APPENDIX 4 CORRESPONDENCE WITH TRANSPORT FOR NSW

Subject: RE: SSD-10452: Blue Springs Road, Gulgong; Stubbo Solar Farm

BLUE SPRINGS ROAD, STUBBO		
VEHICLE TURNPATH PLAN COPE ROAD - MC00		
PROJECT NO BTE-210038	SHEET NO SHT-TP-0001	STATUS CONCEPT DESIGN

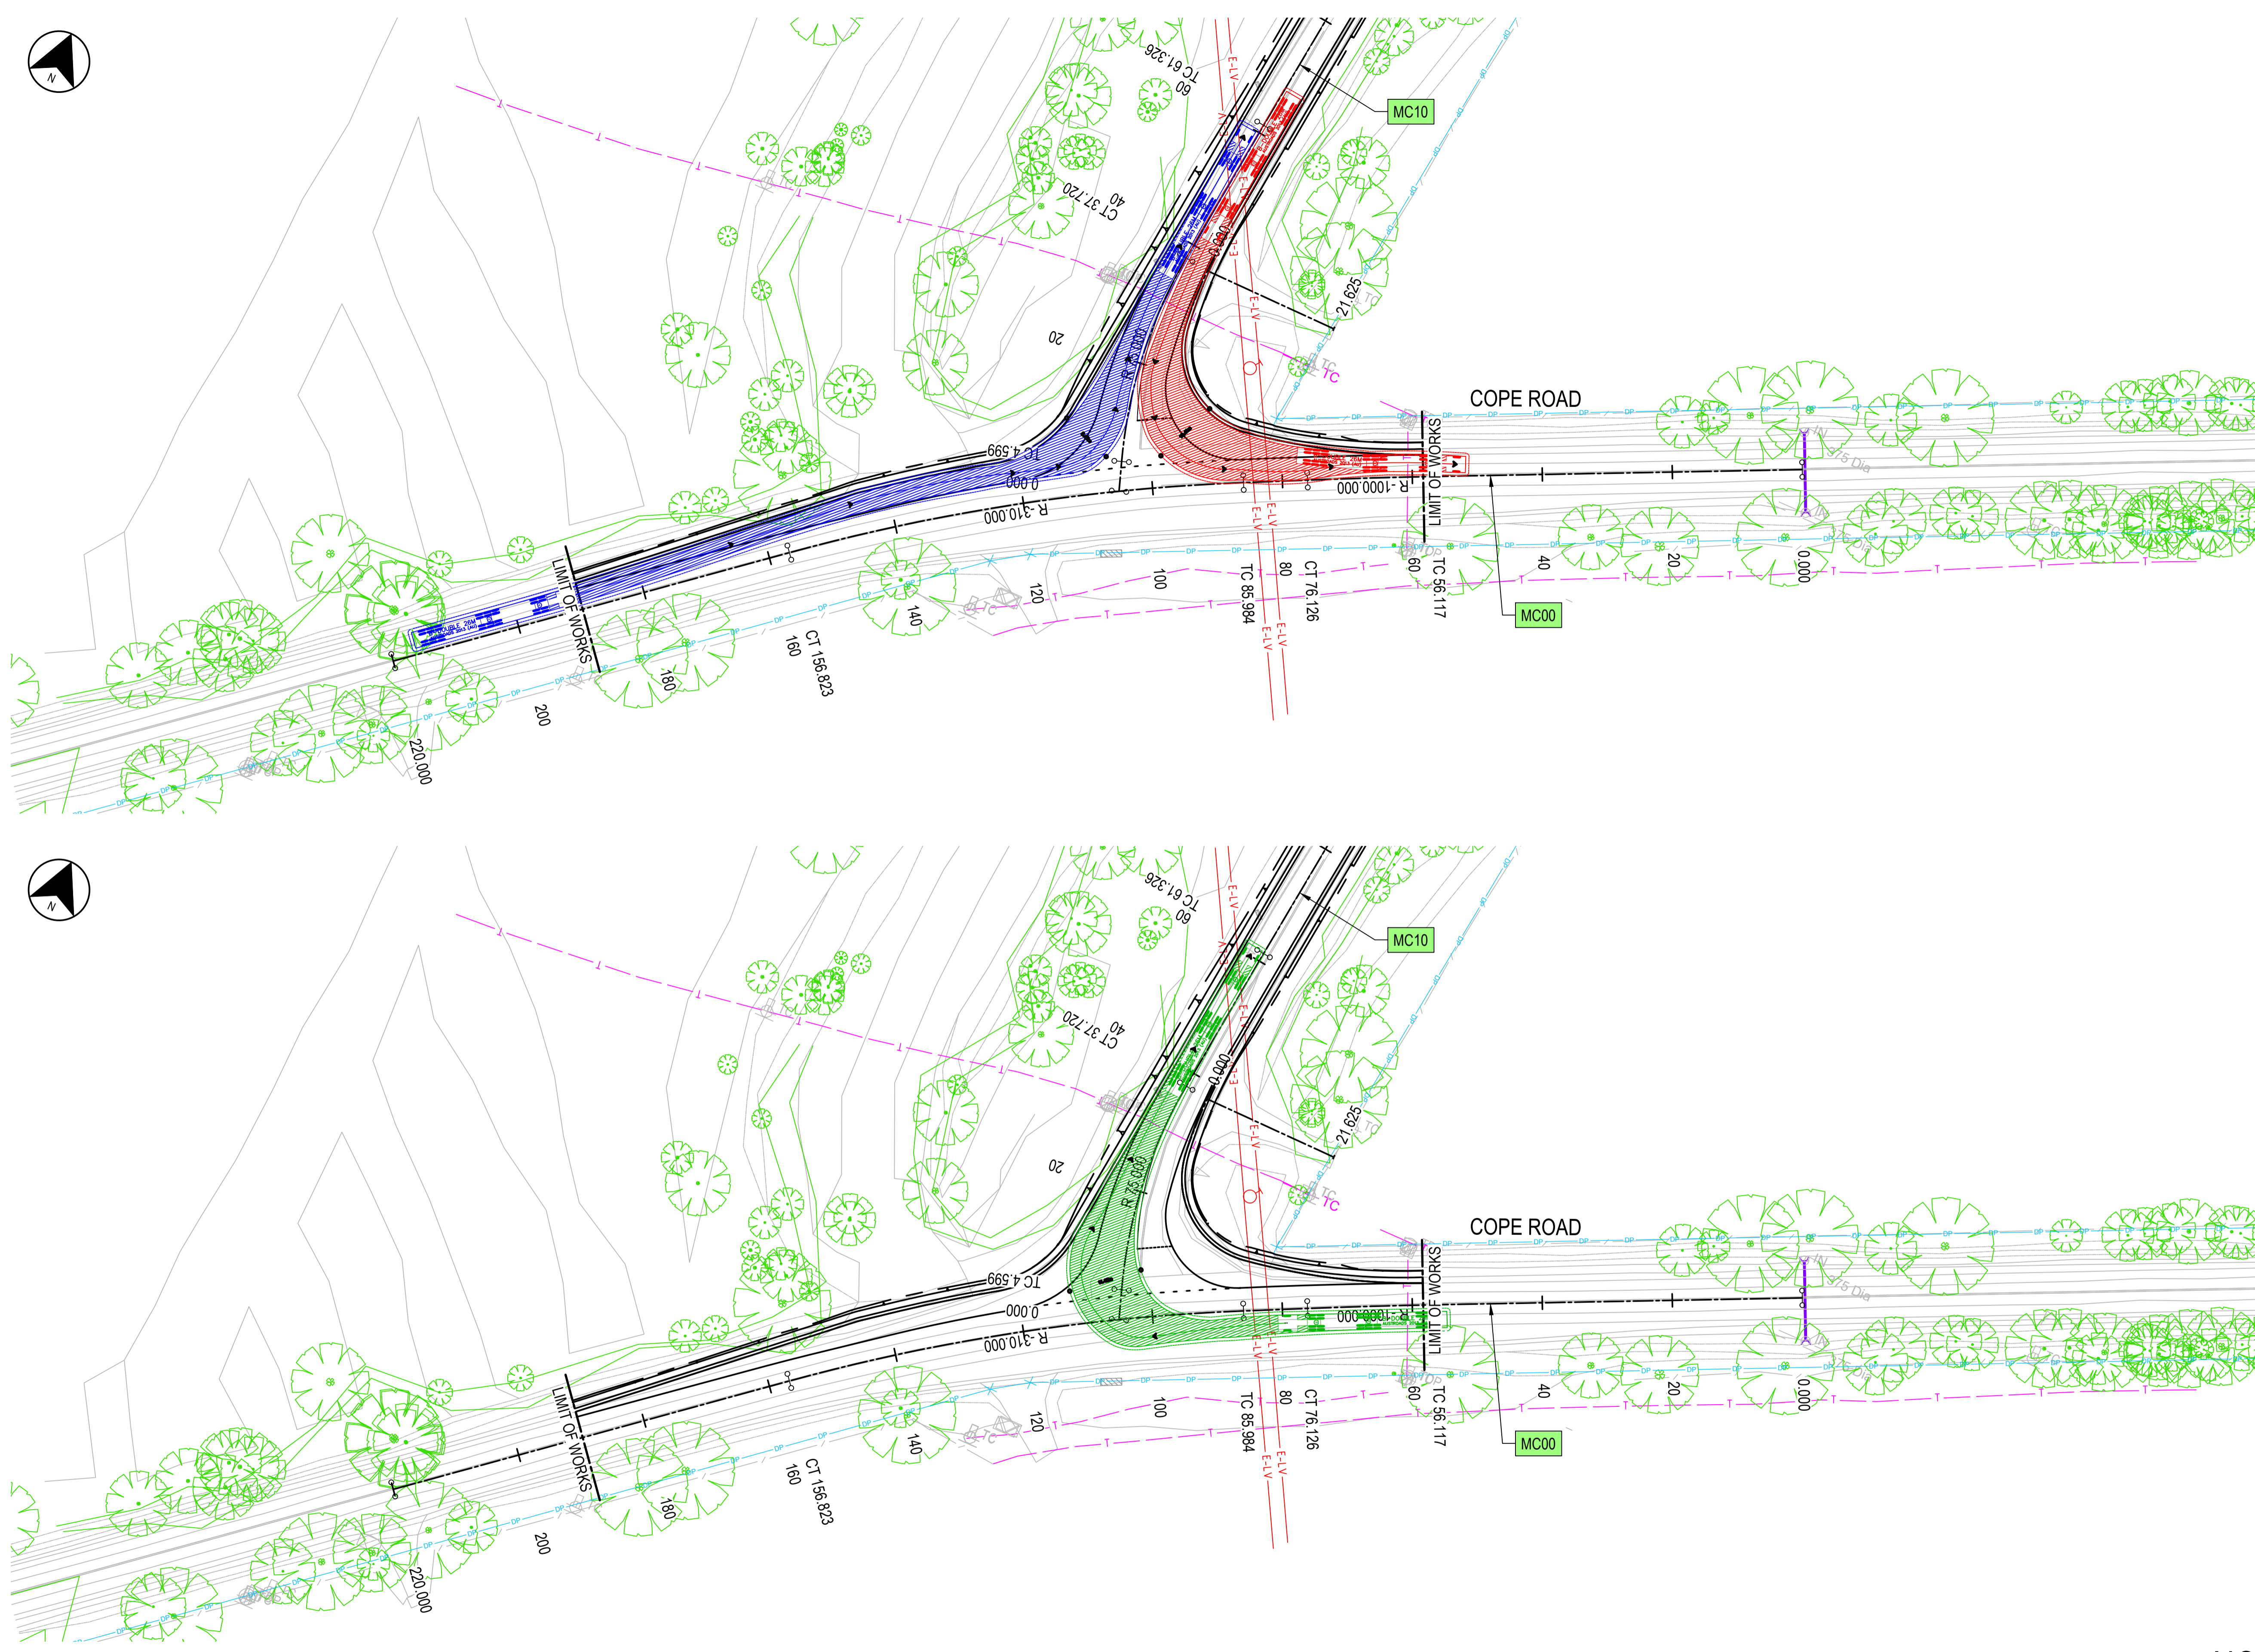
The concept design provided to TfNSW on the 19 of May 2021 only identifies the BAL intersection treatment and does not include the BAR intersection treatment which is required as per the letter from TfNSW on the 20 of January 2021.

The BAR/BAL are required to be designed for the largest vehicle and it is noted in the letter that all turning movements at the intersection of Cope and Blue Springs Roads can be performed without traversing into the opposing lane of traffic. Swept path analysis would be required to prove these two points and must accompany the s138(2) application required to be lodged with Mid-Western Regional Council and referral to TfNSW.

- Section 3.1.1 – Figure 5 shows the typical existing BAR treatment
- Design Issues Log – ID34
 - Existing BAR treatment on Cope Road at Blue Springs Road intersection, width does not comply with Austroads Guide to Road design part 4A treatment requirements by less than 0.5m. As discussed during the site inspection on 12.05.21, it is proposed to retain the existing BAR treatment to avoid property impacts (including existing trees, fences and property boundaries).

Austroads Guide to Road Design Part 4A: Unsignalised and Signalised Intersections	7.5.1 Urban Basic Right-turn Treatment (BAR) Figure 7.6: Basic right-turn treatment (BAR) for a two-lane urban road	C = 6.5 + 0.5 (Based on 26m B-double @350m R @ 100km/h) = 7.0m Curve widening refer Table 7.13 AGRD Part 3 (Storing B-double, passing Semi-trailer) A = (0.5 x 100 * (7.0m - 3.25m)) / 3.6 = 52m S = 26m X = 15m W = 3.25m
---	--	---

It was noted when assessing the existing BAR treatment against the above design criteria that:

- The existing BAR treatment generally provides a standard BAR treatment width, without allowing for curve widening
- Providing further widening with no roadside drainage treatment would cause wearing of the pavement /verge / embankment
- Providing a minimal depth table drainage treatment would result in the existing property to be impacted within the fenceline and boundary, along with significant trees
